**Consultation Response from KC,  
Highways Development Management****2026/92450 Workshop between, 12 & 14/16, Temple Street, Lindley, Huddersfield, HD3 3JG****Demolition of existing workshop and erection of detached dwelling****Date Responded: 28 September 2026****Responding Officer: Sheila Henley****Responding Ref: 2-20SE/33****Recommendation: No Objection.**

Plan ref: 298 (0-) 02 - Scheme As Proposed

- Materials
- ① Reclaimed natural walling stone.
 - ② Through coloured rendered wall finish.
 - ③ Blue slate roof.
 - ④ Grey windows with natural stone heads, cills and mullions.
 - ⑤ Grey doors.
 - ⑥ Black rain water goods.
 - ⑦ Grey framed rooflights.
 - ⑧ Inset Solar Panel.

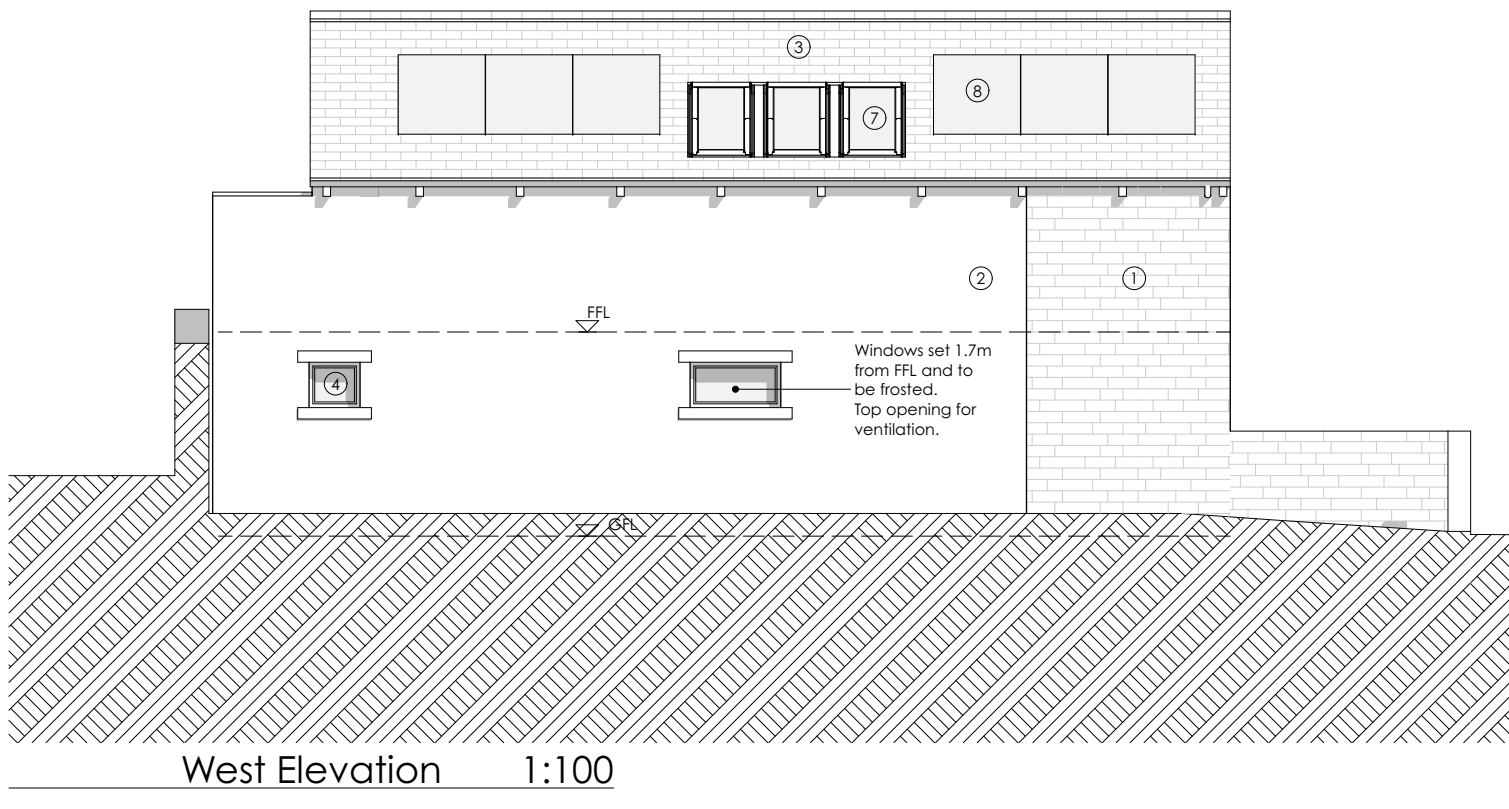
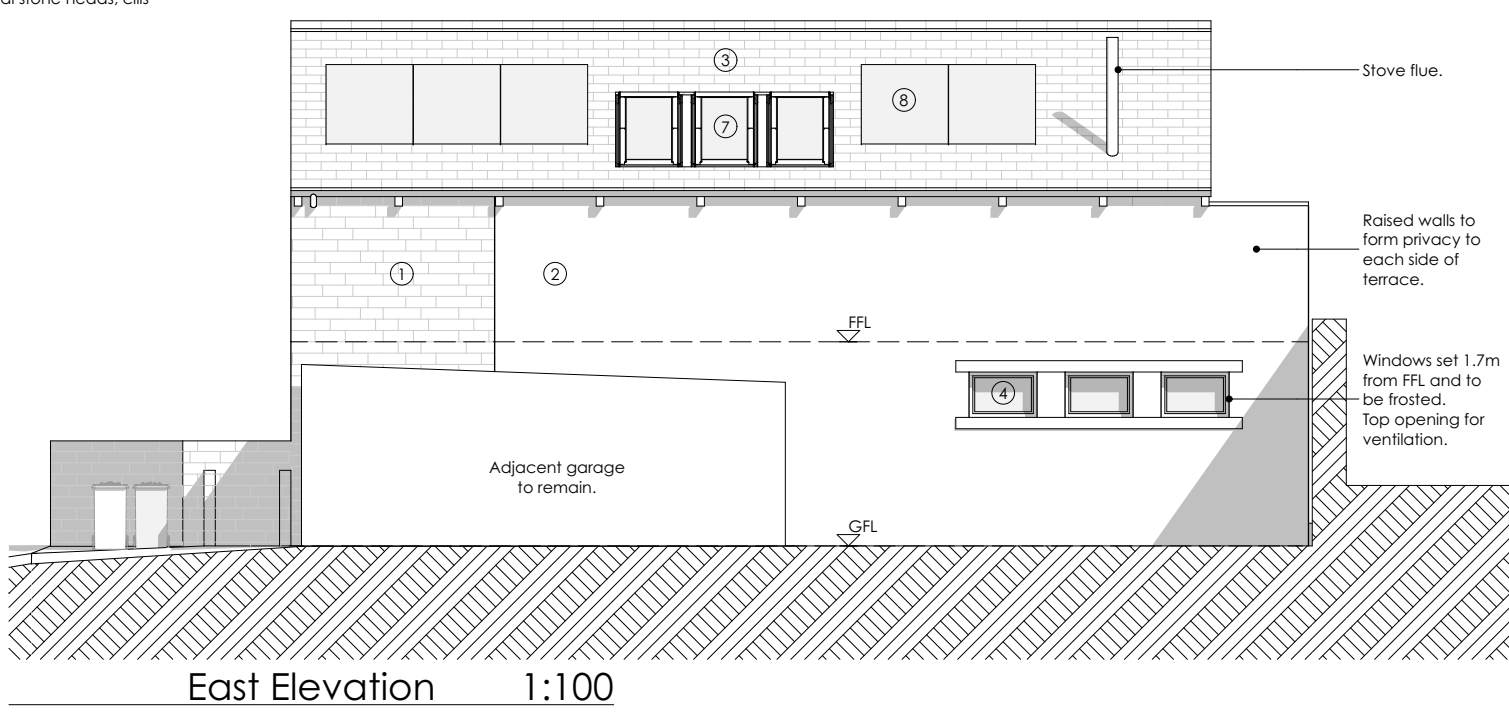
There appears to be no space for cycle parking to meet policies LP20 and LP22, support Active Travel and mode choice and as desired within the Kirklees Highway Design Guide SPD at one space per unit or as preferred at one space per bedroom to meet later guidance in LTN1/20.

An electric vehicle charging point is necessary to support LP20 and LP24 for reasons of sustainable travel and lower emissions. Details of its position will be required.

The amount of space is adequate for two cars and usage by pedestrians providing adequate clearance is achieved from the intended window. The amount of car parking would be sufficient for a two bedroomed dwelling in keeping with suggested provision in the KHDG SPD.

Any new areas for hardstanding should be in a permeable surface material.

Accordingly, the proposal is acceptable in highway terms for no objection to be raised. Installation of an evcp is necessary and the provision of cycle parking if there is space.
